From: [Les Stevens](#)
To: [A303 Sparkford To Ilchester](#)
Cc: [Les Stevens](#)
Subject: Response to ExQ3 on behalf of Parish Councils of Queen Camel, West Camel and Sparkford.
Date: 03 May 2019 17:06:23
Attachments: [PINS ExQ3 - Parish Councils" Joint Response 03 05 19.pdf](#)

Joint Feedback from Queen Camel, West Camel and Sparkford Parish Councils to PINS Written Questions (ExQ3)

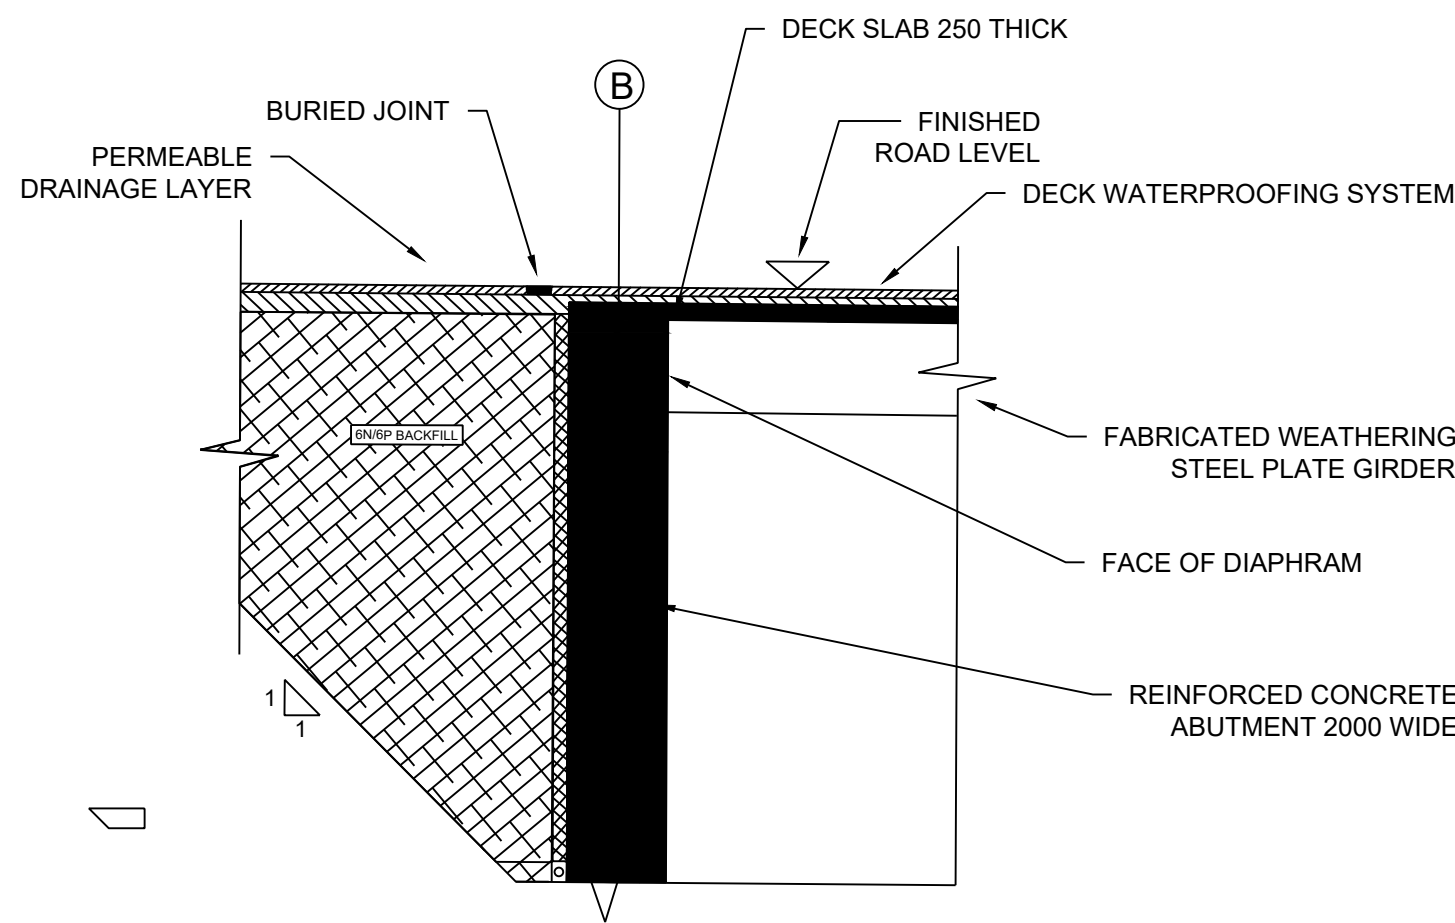
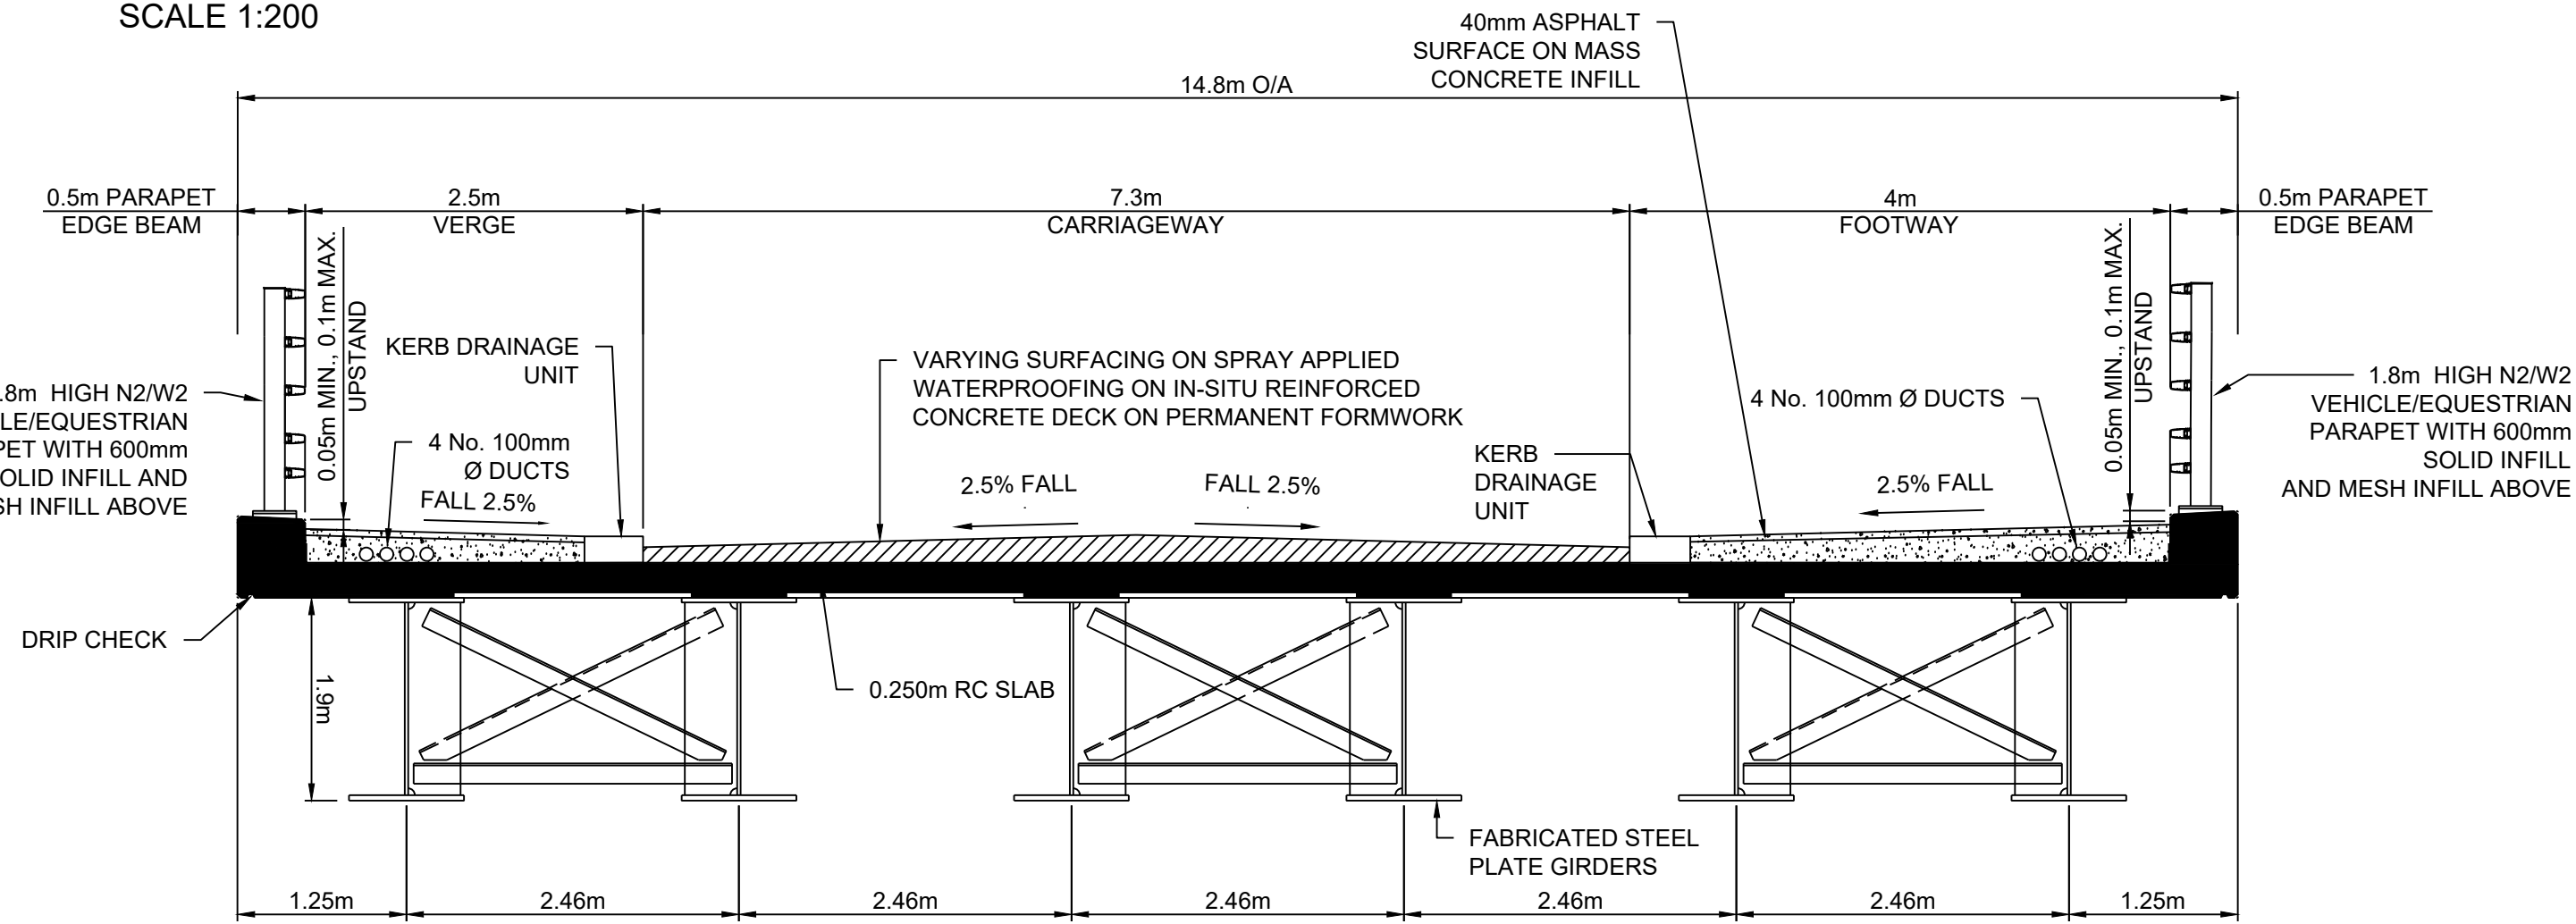
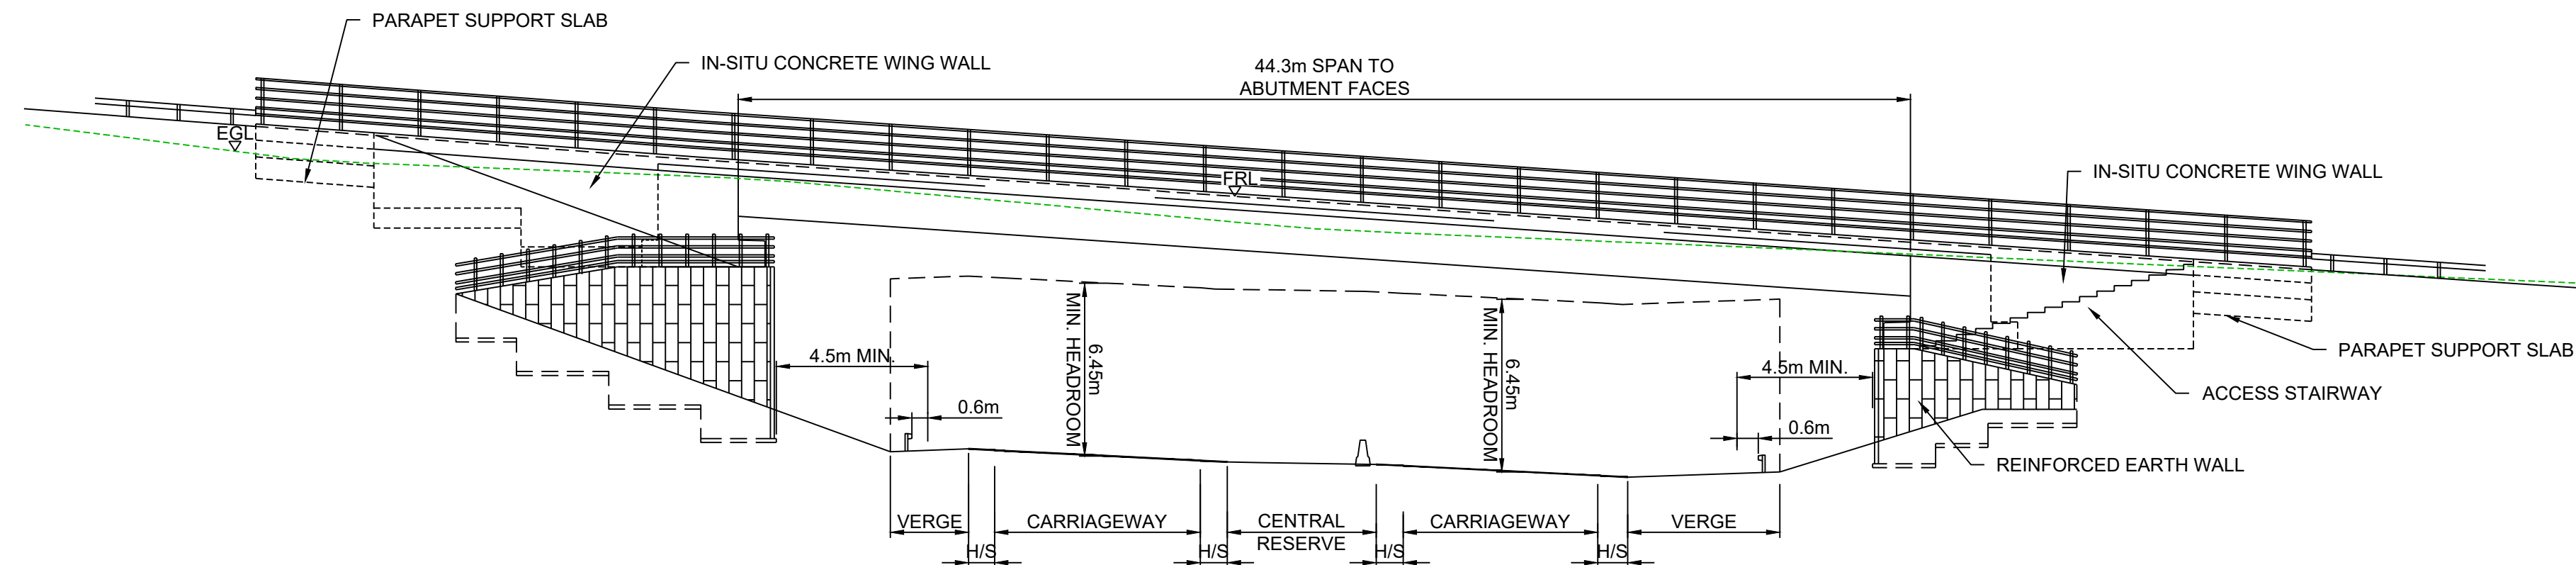
We have commented on question 3.7.4 which appears to be a misunderstanding on the part of the Inspectors as the PCs have never suggested that the Steart Hill Overbridge wasn't required.

Question No.	Question to:	Question	Answer
3.7.4	The Applicant	Parallel Road	<p>Correction – The PCs have <u>never</u> suggested that provision of a Parallel Road would not require the Steart Hill overbridge. What was suggested in Mr Philip Gamble’s submission was that provision of a LPR would obviate the need to provide an East Bound junction at Downhead.</p> <p>The cost savings cited by the PCs and other IPs come from less disruption to A303 traffic and a clear work site which would in turn remove the need to construct temporary haul routes north and south of the existing A303 and provision of the temporary Bailey Bridge by the proposed Steart Hill overbridge. Other benefits come from built in resilience and future proofing the scheme if / when this section of the A303 becomes an ‘Expressway’ by providing a route for barred NMU and Agricultural vehicles.</p>
